July 12, 2022

Re: SAFStor Self Storage – 10600 Central Ave SW
ESC Plan Engineers Stamp Date: 7/7/2022 – (L08E013)

Based upon the information provided in your submittal received on 7/8/2022, the above referenced ESC Plan cannot be approved until the following comments are addressed.

DRAWN BY
RMG
DATE
11/15/2022
2021064_ECP PLAN
SHEET #
SW-1
JOB #
2021064

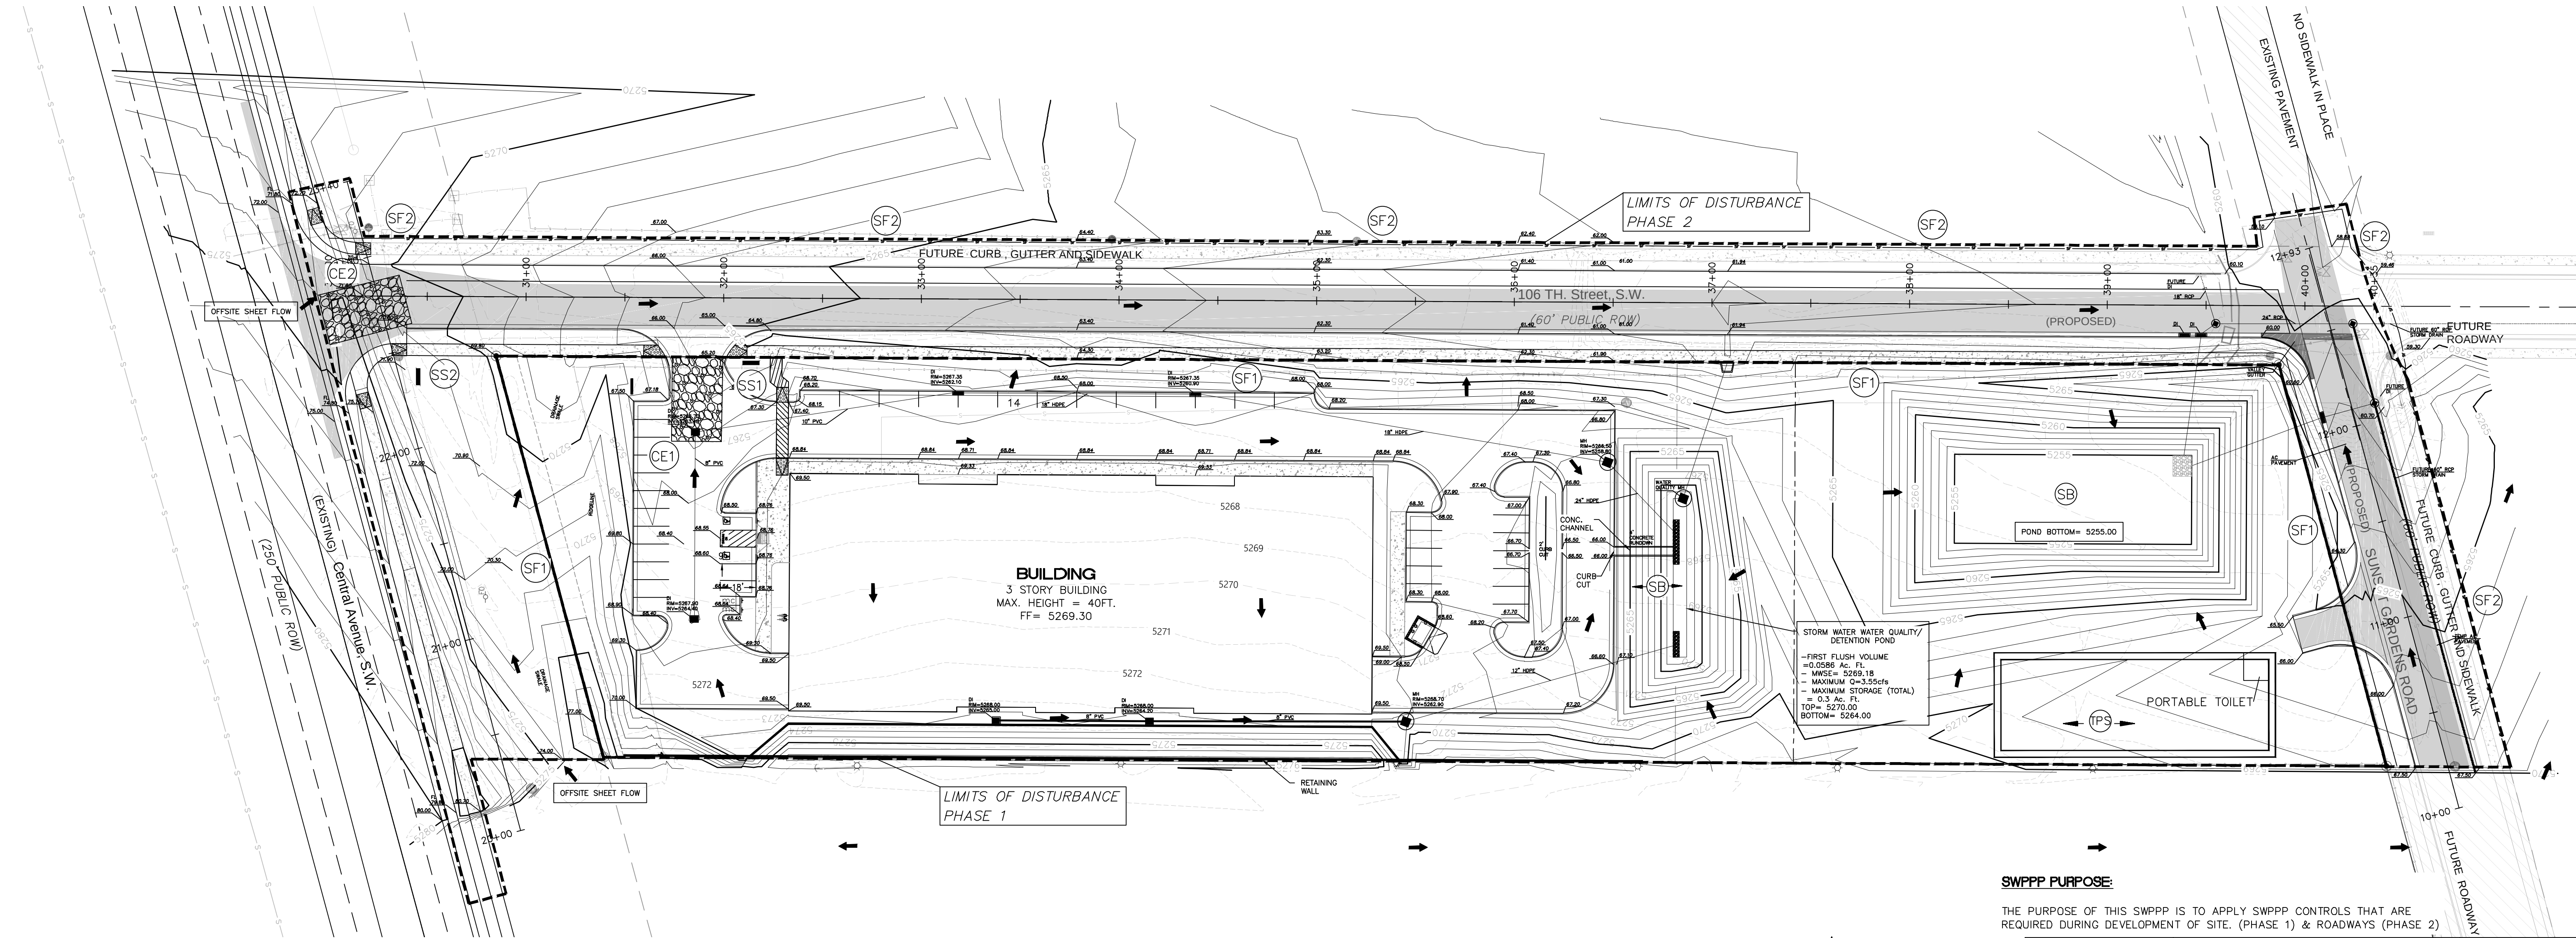
3. The Ponds should be labeled as Temporary Sediment Basins (SB) and should be listed as an early item in the sequence of construction.
4. The ESC Plan can't be approved for Grading, Building Permit, or Work Order until the property owner's NOI has been reviewed and approved by City Stormwater Quality per Albuquerque Code § 14-5-2-11(a)
[https://codelibrary.amlegal.com/codes/albuquerque/latest/albuquerque_nm/0-0-0-19897#:~:text=the%20property%20owner%20is%20to%20provide%20the%20Construction%20General%20Permit%20\(CGP\)%20Electronic%20Notice%20of%20Intent%20\(eNOI\)%20documentation%20that%20contains%20the%20property%20owner%20name%20and%20contact%20information%20a%20minimum%20of%2014%20days%20prior%20to%20earth%20disturbance%20and%20prior%20to%20obtaining%20Work%20Order%20or%20Building%20Permit%20approval](https://codelibrary.amlegal.com/codes/albuquerque/latest/albuquerque_nm/0-0-0-19897#:~:text=the%20property%20owner%20is%20to%20provide%20the%20Construction%20General%20Permit%20(CGP)%20Electronic%20Notice%20of%20Intent%20(eNOI)%20documentation%20that%20contains%20the%20property%20owner%20name%20and%20contact%20information%20a%20minimum%20of%2014%20days%20prior%20to%20earth%20disturbance%20and%20prior%20to%20obtaining%20Work%20Order%20or%20Building%20Permit%20approval) .

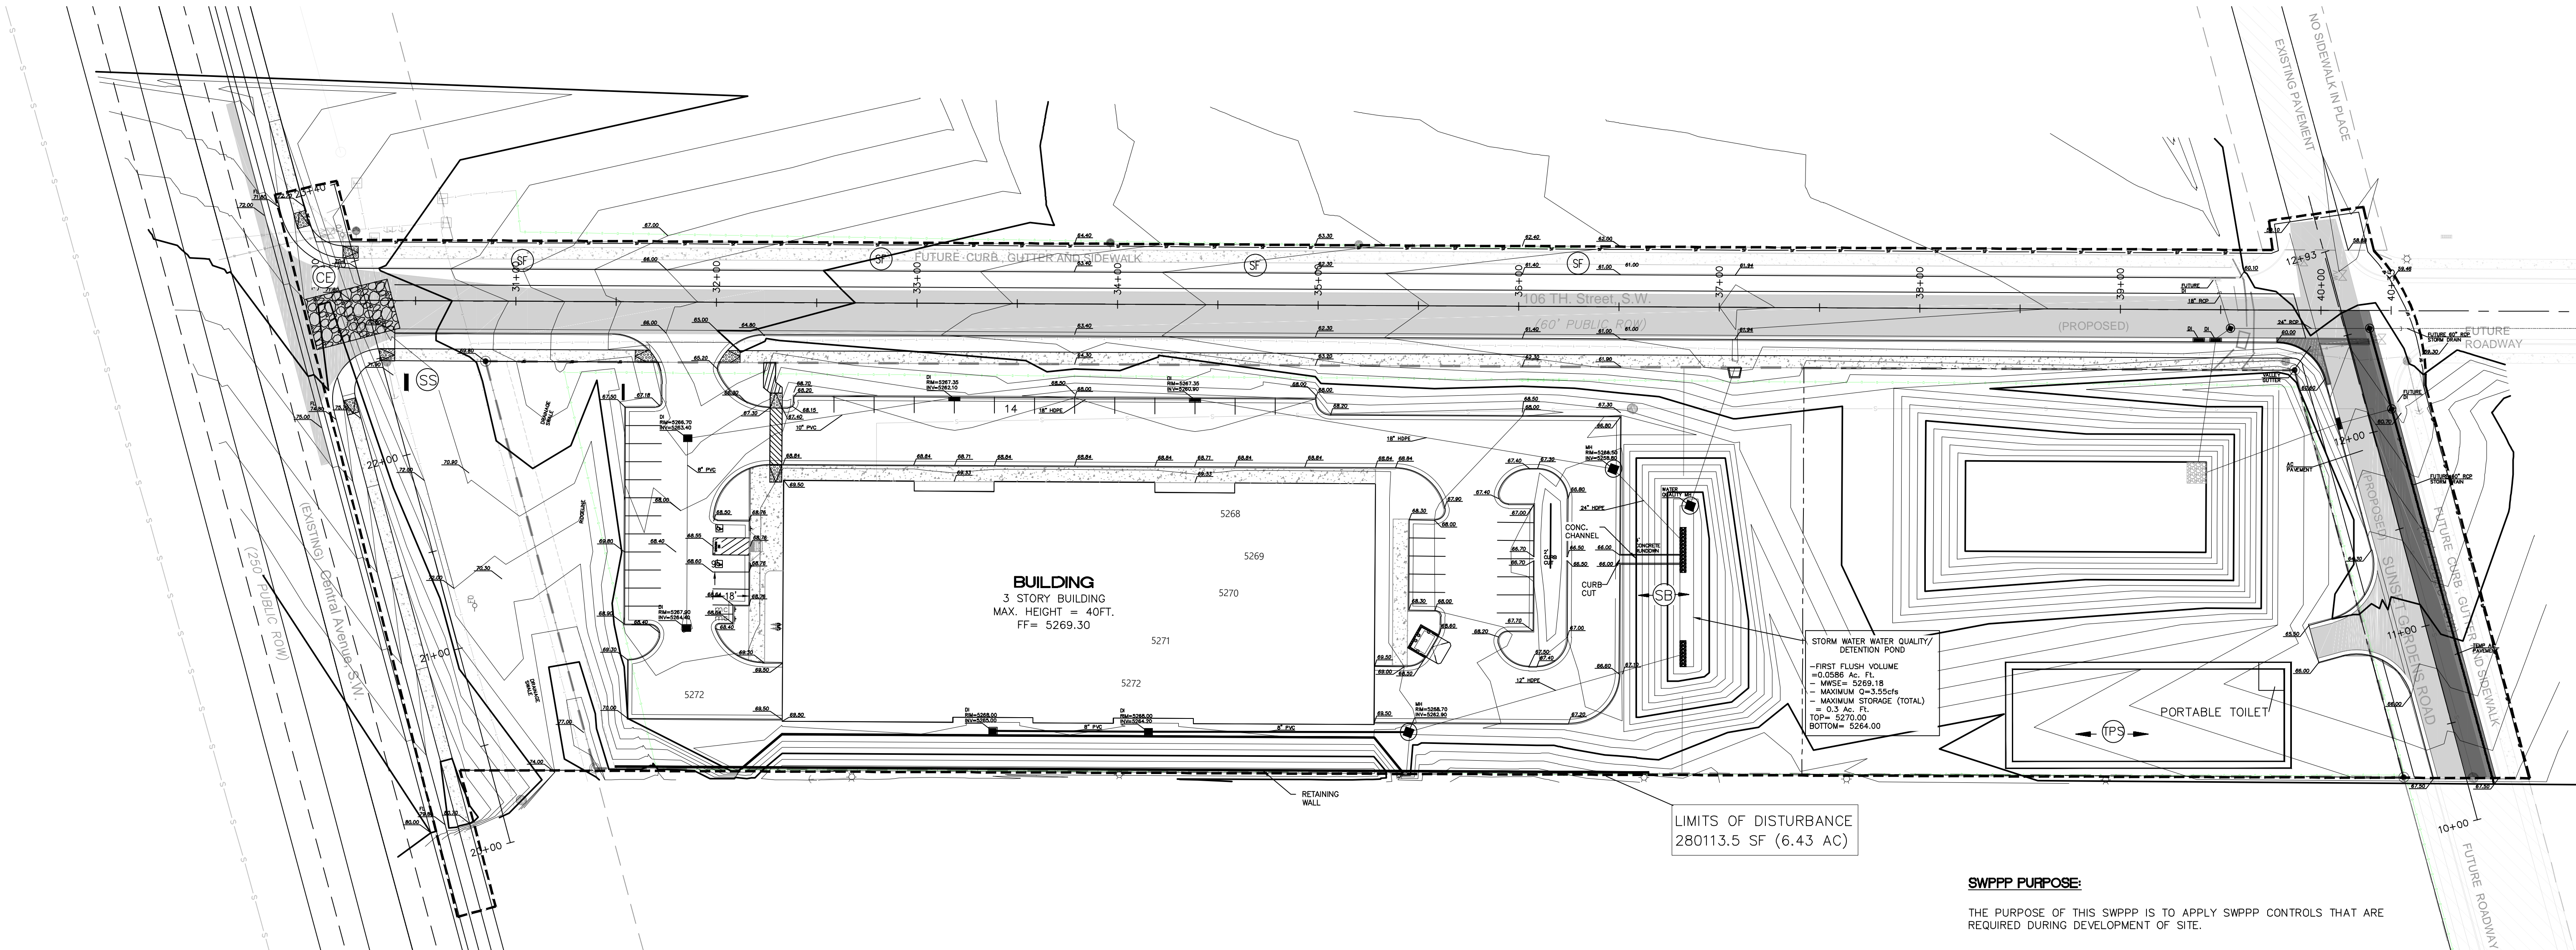
1. The ESC Plan can't be approved until after Hydrology approves the G&D Plan for each specific purpose Grading, Building Permit, and Work Order. The only purpose Hydrology has approved so far is Conceptual. The existing and proposed grades must be shown on the ESC Plan, and they must agree with the Grading Plan approved by Hydrology (CGP 7.2.4.b.ii).

2. Identify locations of concentrated flow paths that enter and exit the disturbed areas. Identify locations where sheet flow enters and exits the disturbed area. Show on-site drainage patterns of stormwater before and after major grading activities. (CGP 7.2.4.f)

6. I can't tell the difference between building, sidewalk, asphalt, and dirt on the ESC Plan. These structures must be clearly identified in the SWPPP per CGP 7.2.4.b.vi. The same information is required in the ESC Application. You may attach a copy of the Site Plan to both the SWPPP and the ESC Application to address this requirement.

7. The SWPPP must include site-specific interim and permanent stabilization per CGP 9.4.1.c.i. The Landscape Plan and Work Order sheets can be used to satisfy this requirement and should be submitted separate from the ESC Plan with the application to the Stormwater Quality Section of the Planning Department and they should be included in the SWPPP. Provide a specification on the ESC Plan for any disturbed areas not covered by the Landscape Plan or Work Order sheets.

8. Update the engineer's stamp date each time the plan is changed.
